In reply please quote: 17/22684

3 September 2021

**SSD-8859 – REQUEST FOR ADVICE TO RESPONSE TO SUBMISSIONS FOR PROPOSED
SUBDIVISION TO 1111-1141 ELIZABETH DRIVE, CECIL PARK**

Figure 9 | Final concept roadway and intersection design

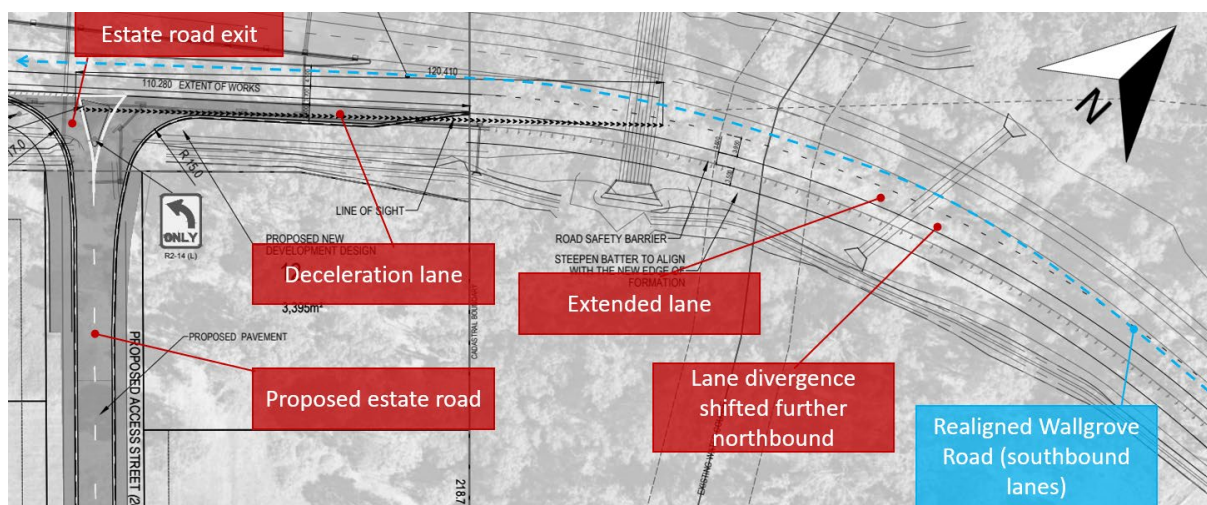
- Vehicles turning left from the realigned Wallgrove Road onto the access road would impact motorists' sight distance when exiting the access road. A Safe Intersection Sight Distance (SISD) assessment shall be undertaken for the proposed intersection of the new access road and the realigned Wallgrove Road. The SISD must demonstrate compliance that the road design complies with Austroads requirements for TfNSW and Council to review. This issue shall be also addressed as a result of the findings of the Road Safety Audit.

- Survey plans indicating dimensions, grades and levels with regard to the proposed realigned Wallgrove Road and access road to and from the development site shall be submitted to Council for assessment. Once the required changes have been confirmed, the provision of access road (future public road) will be reported to Council Services Committee and Traffic Committee for consideration subject to the proposal meet the requirements of TfNSW and the relevant sections of Council.
